RE: **Undi Commerce Park
Technical Review #2**

The responses below correlate to the numbered review comments on your letter dated July 18, 2023.

Harold Christensen
Architect
Lance Mueller & Associates

**Undi Commerce Park
Undi Development LLC
PRELIMINARY LANDSCAPE PLAN**

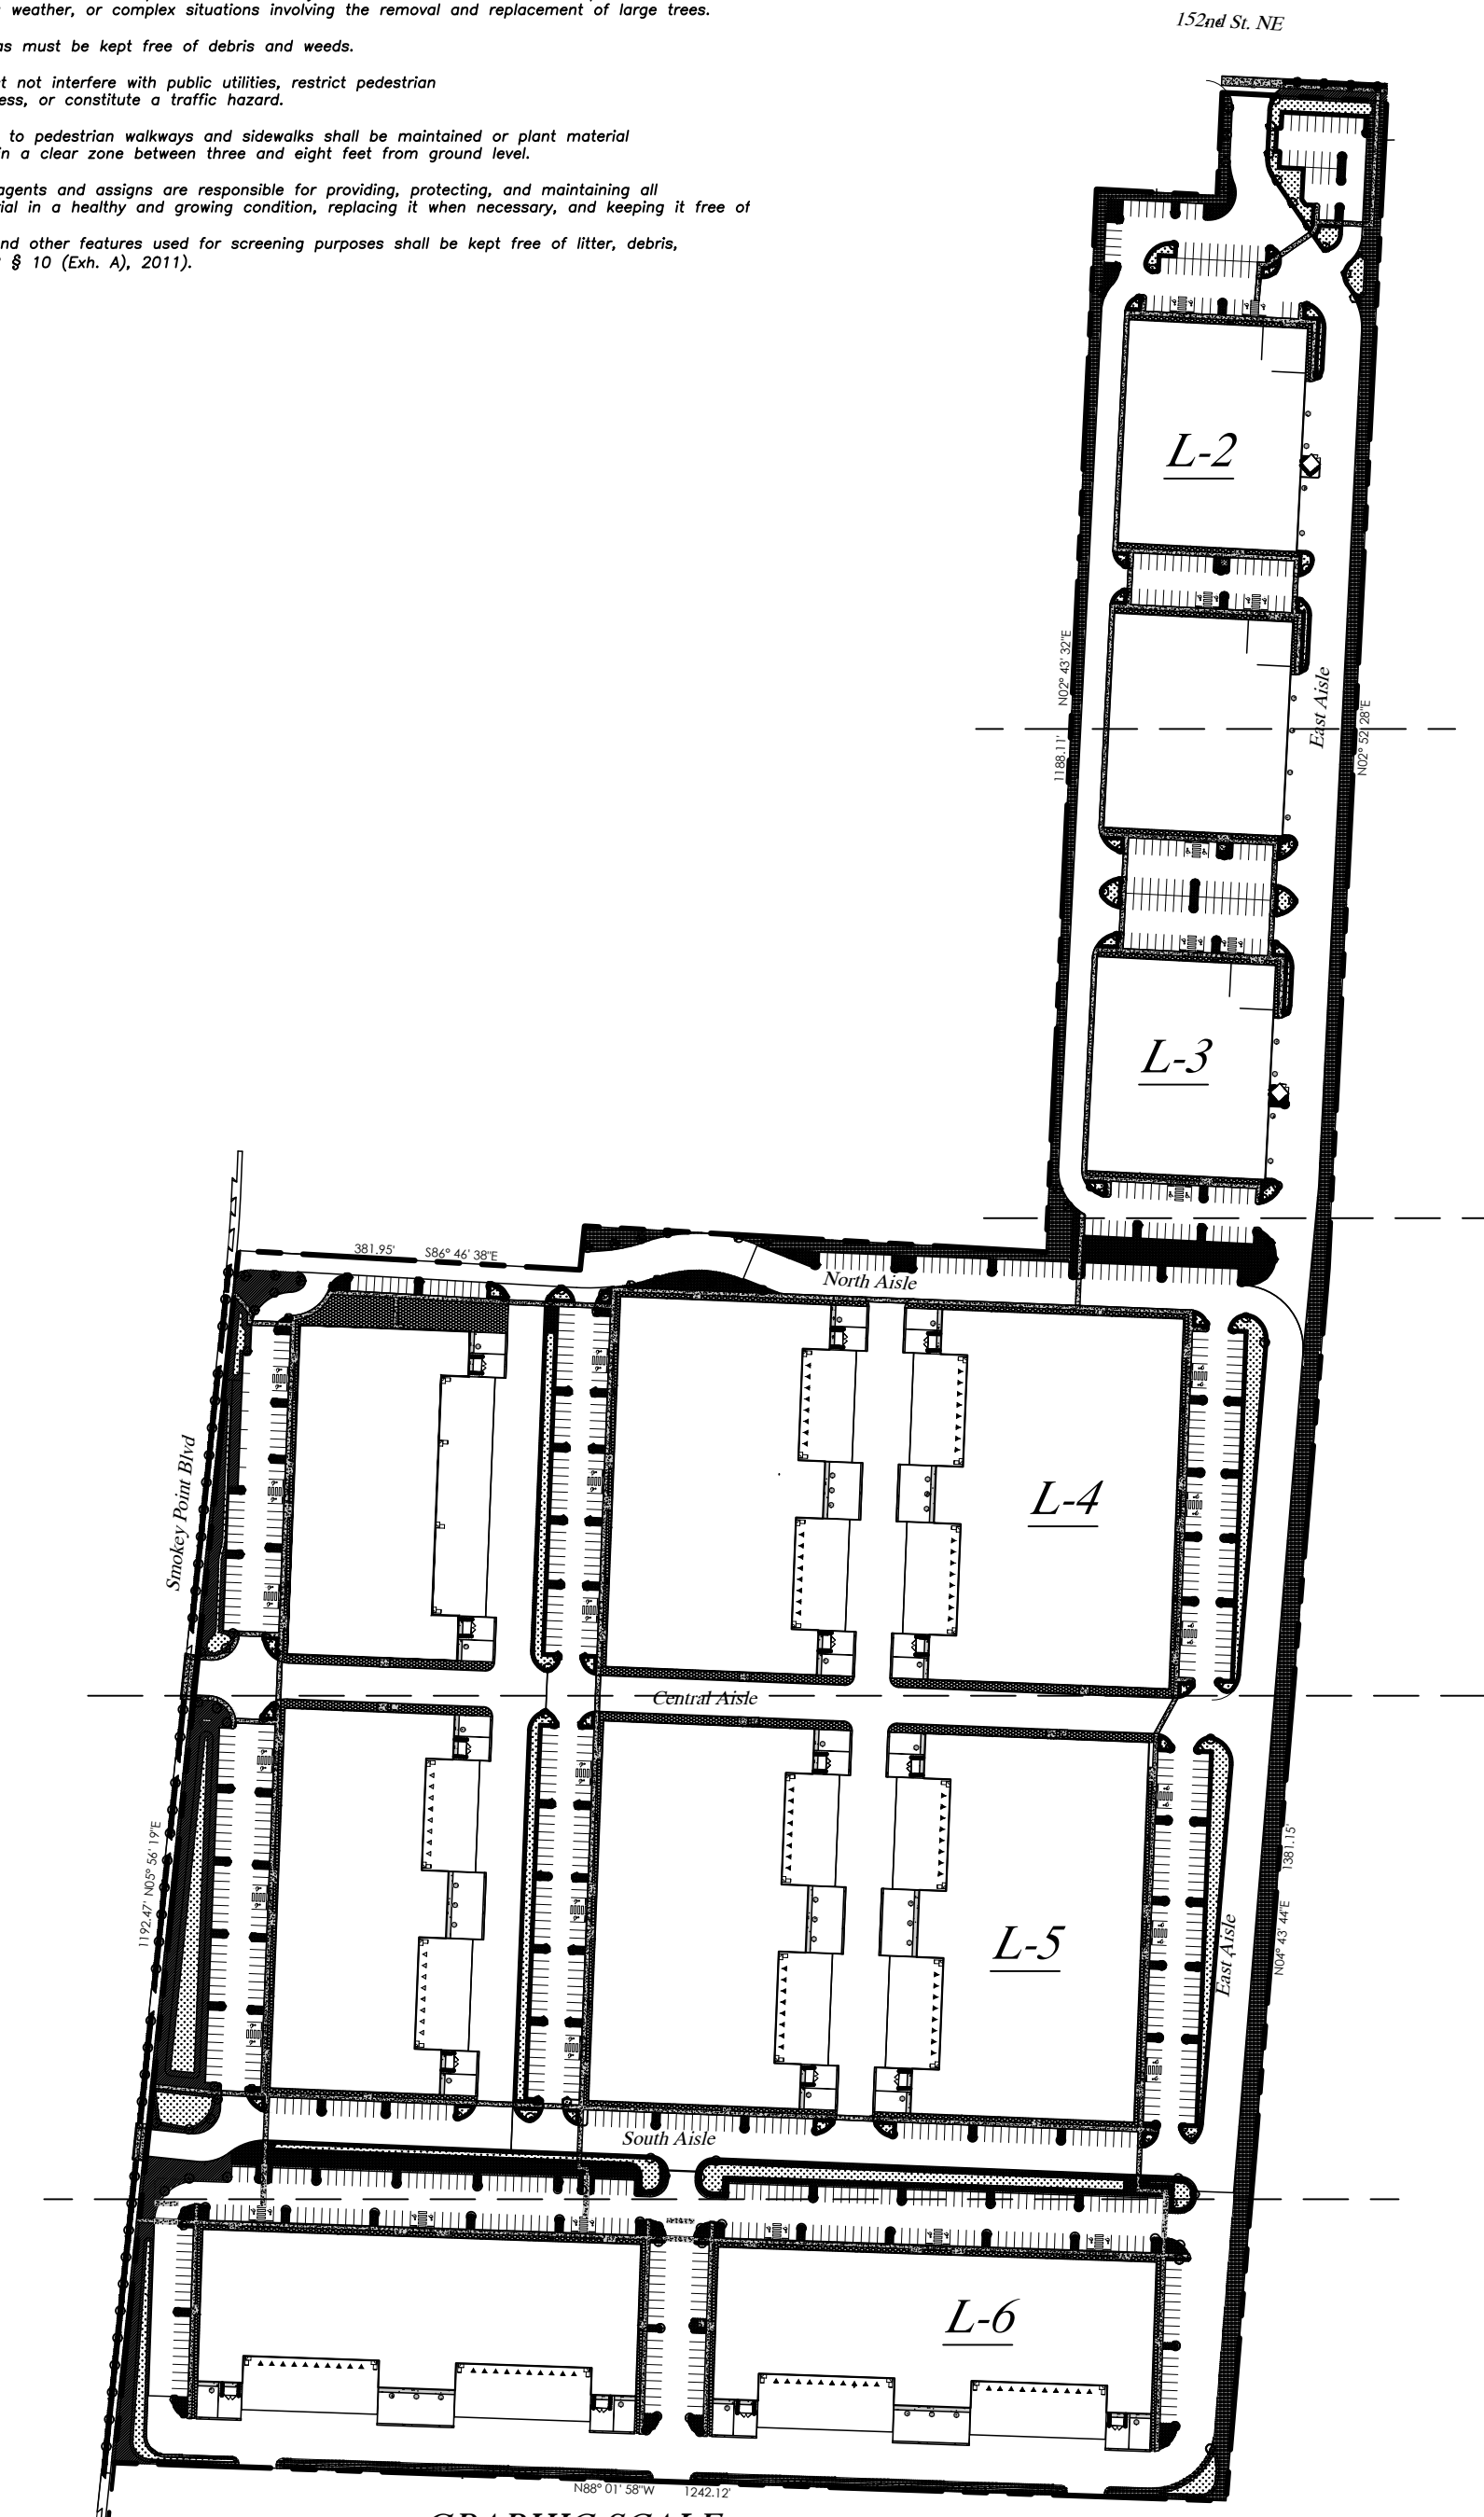
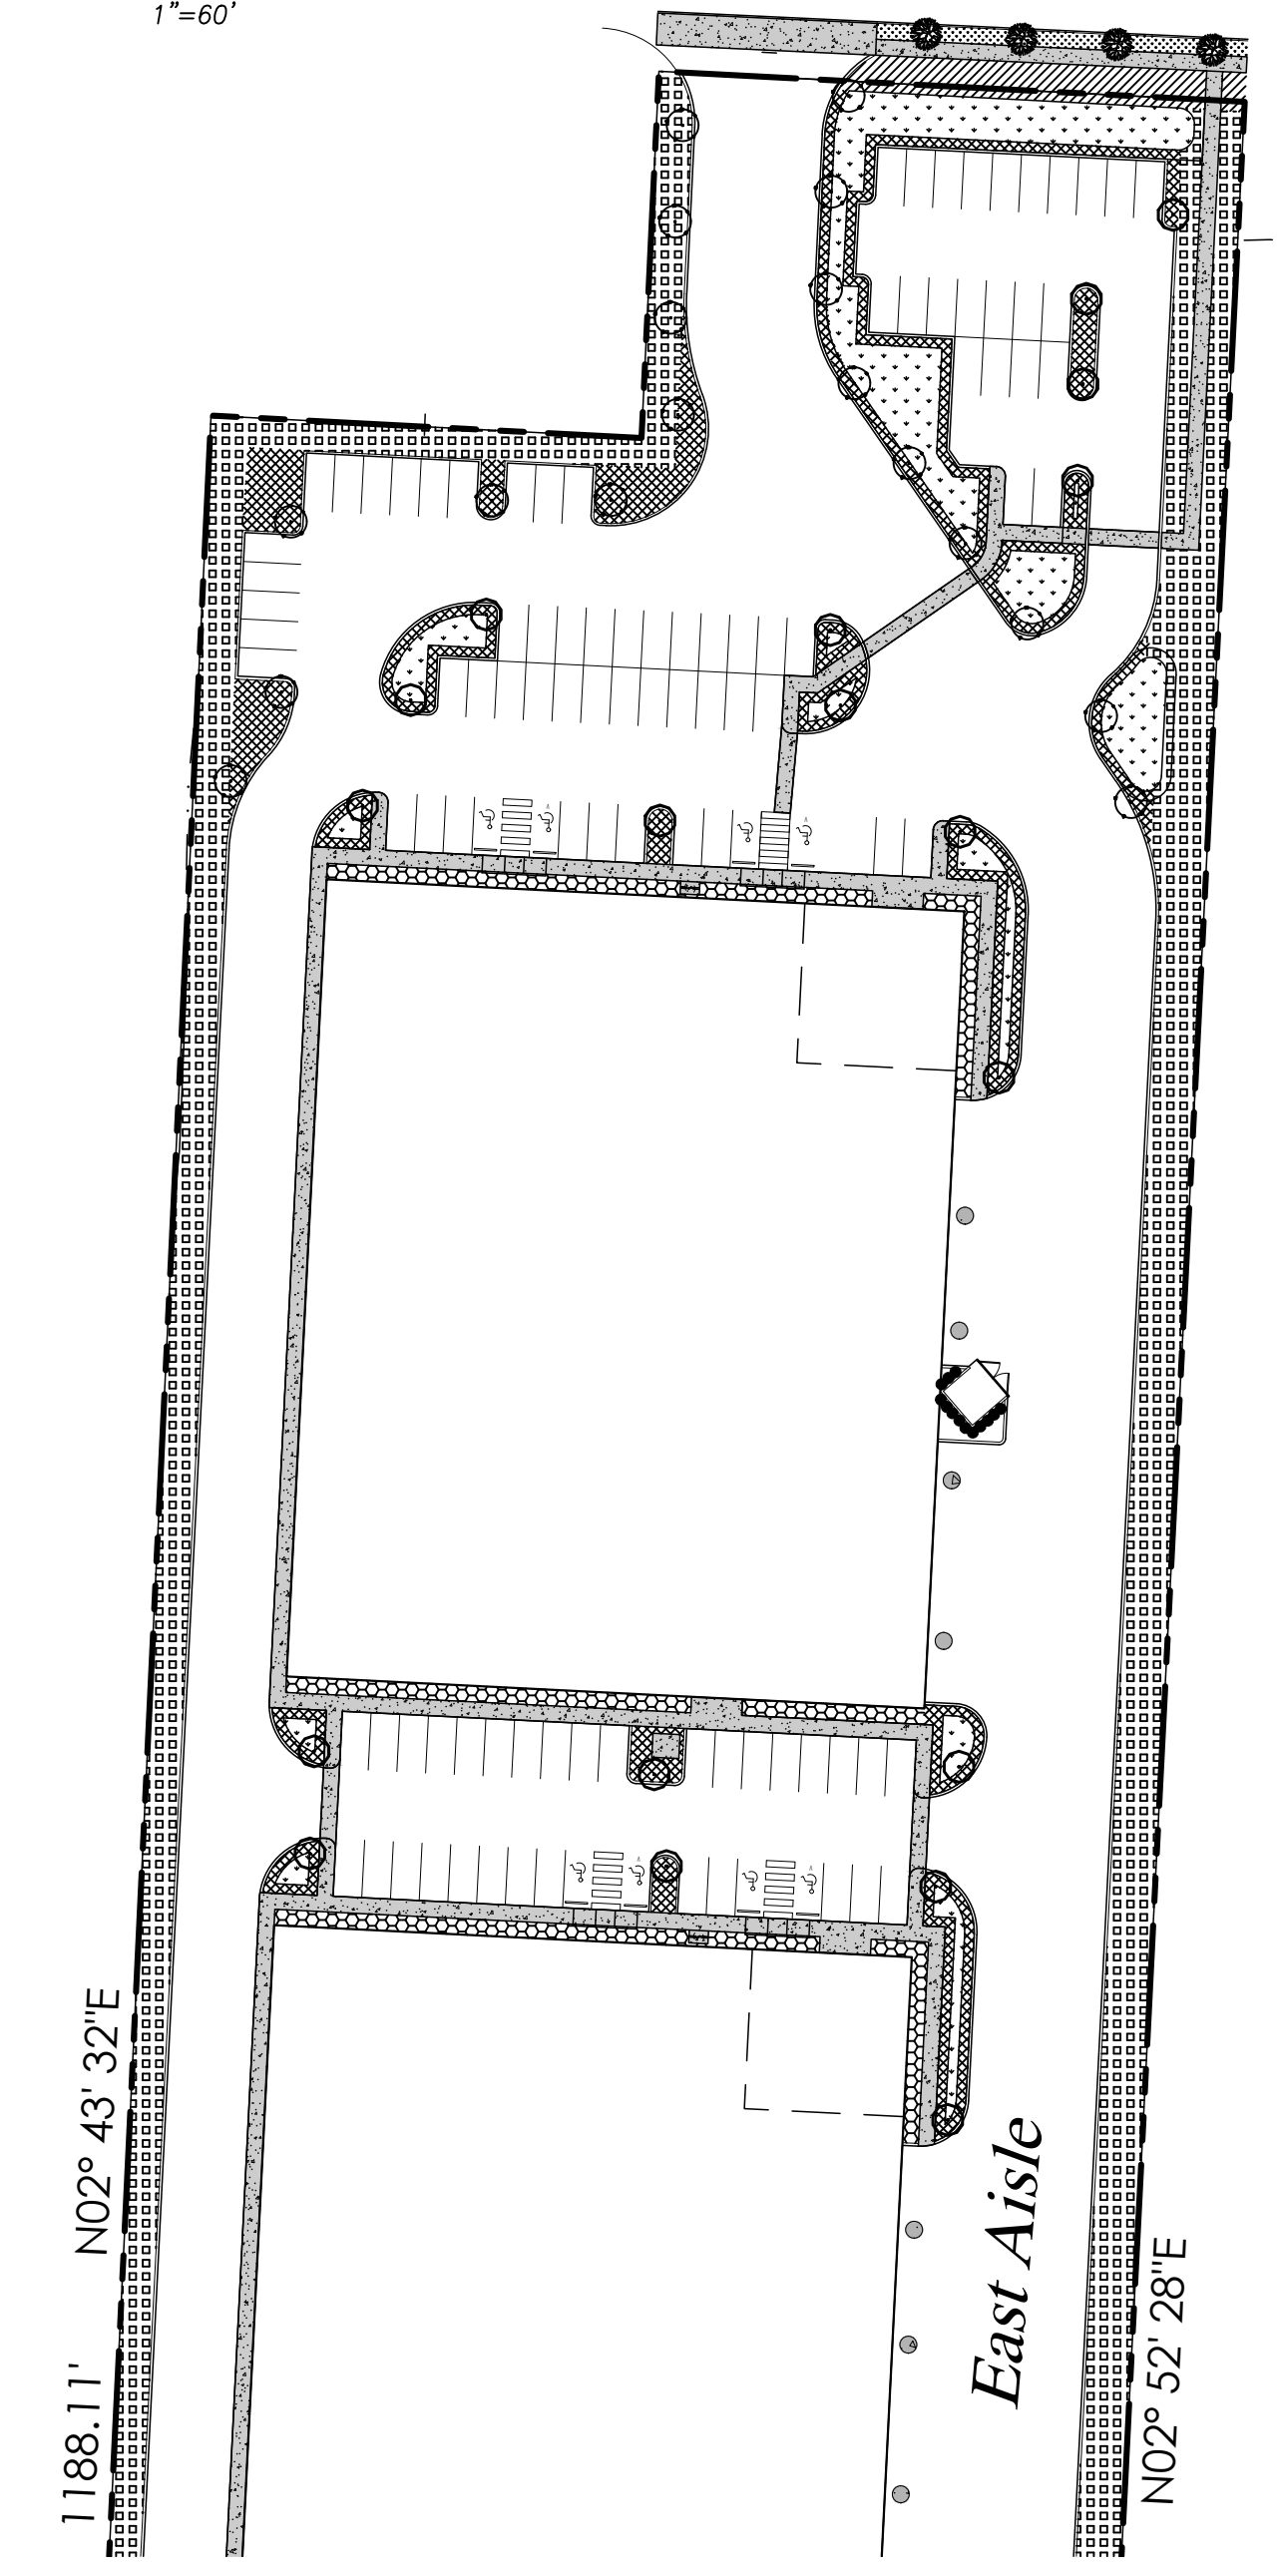
- 1a. Cover sheet showing entire site has been added to the plan set. See sheet A0.0.
- 1b. A pedestrian connection to 152nd Street NE has been added to the architectural, civil and landscape plans. See A0.0, and A1.1.
2. See attached copy of renewed NWP.
3. The access to Scott's site has been eliminated from the scope.
4. Preliminary landscaping plans depicting the elements outlined in your letter has been added to the set. See sheets L-1 through L-6.
5. Acknowledged.
